SUBJECT: Engineering Review Comment  
Mountain View Electric Association Inc. (MVEA)

**Project Name: Hay Creek Subdivision – Final Plat**  
**Project Number: SF253**

**Description:** Proposed development of 6 residential lots located at 3405 Hay Creek Rd. in Township 11S, Range 67W, Section 33.

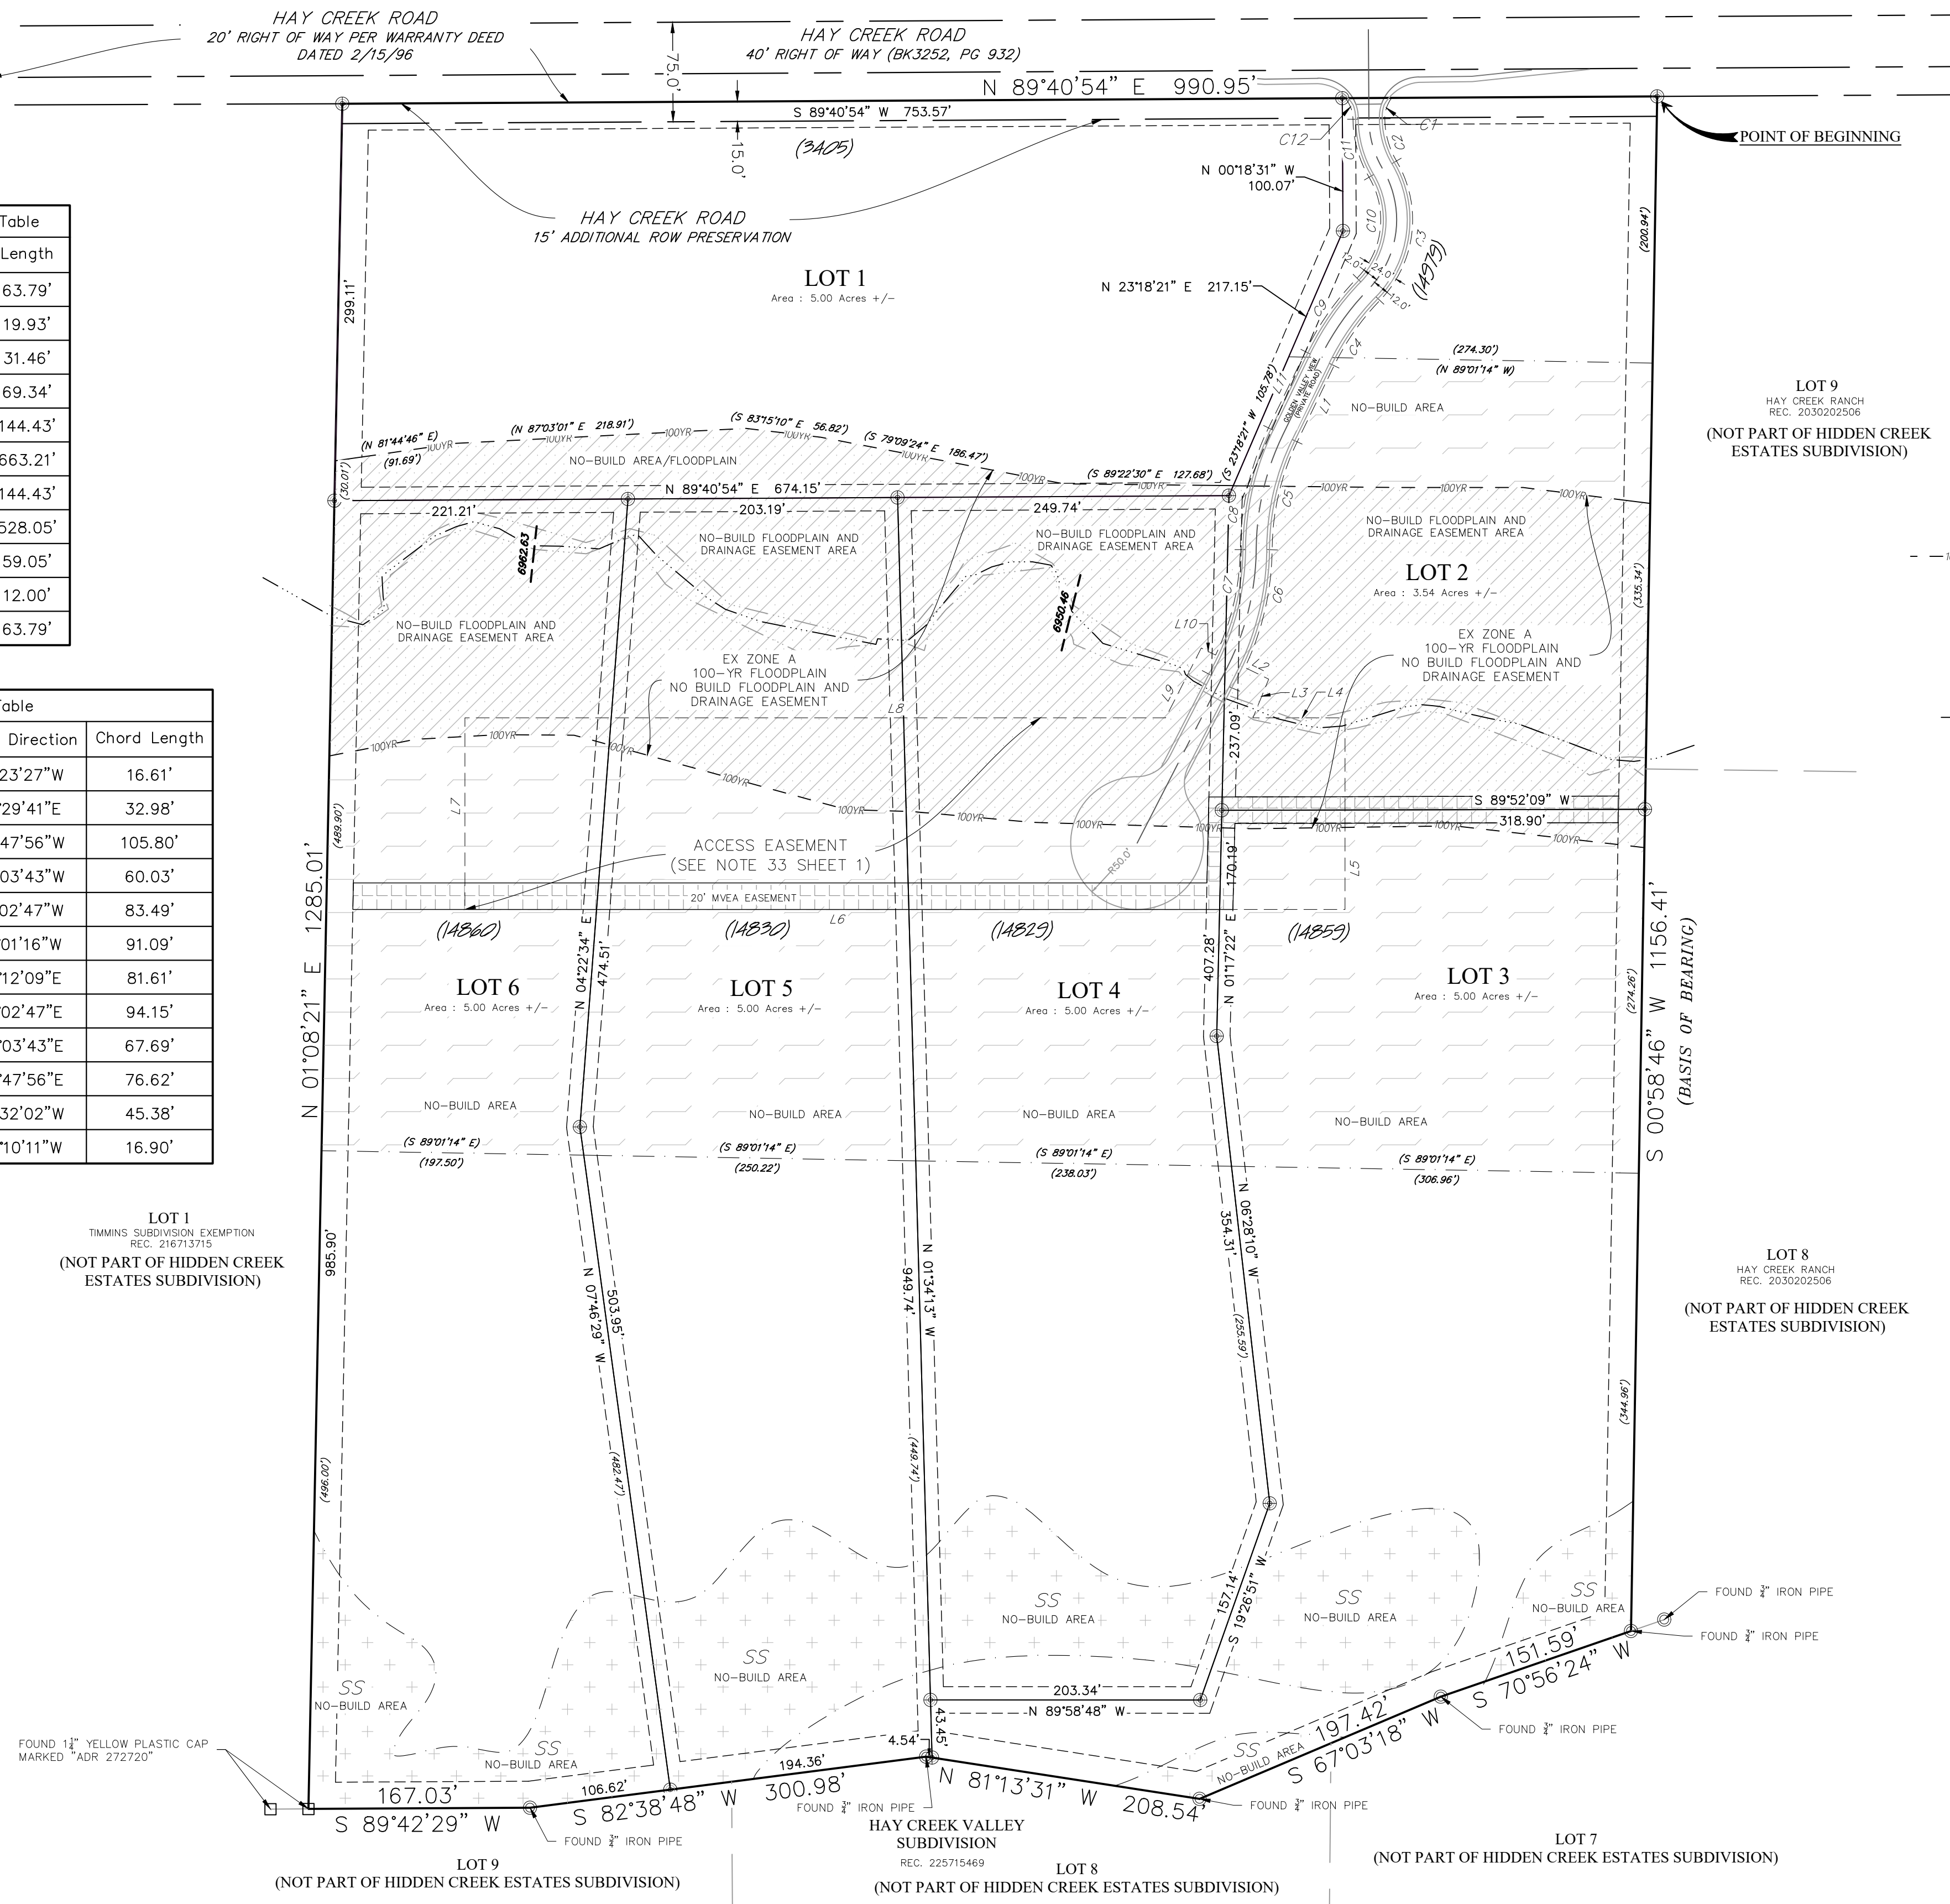
MVEA requests a ten (10) foot front, side, and rear lot utility easement and all tracts, along with a twenty (20) foot exterior utility easement on the plat. MVEA also requests the platting of MVEA's existing facilities with easements on the plat. Additional easements may be required.
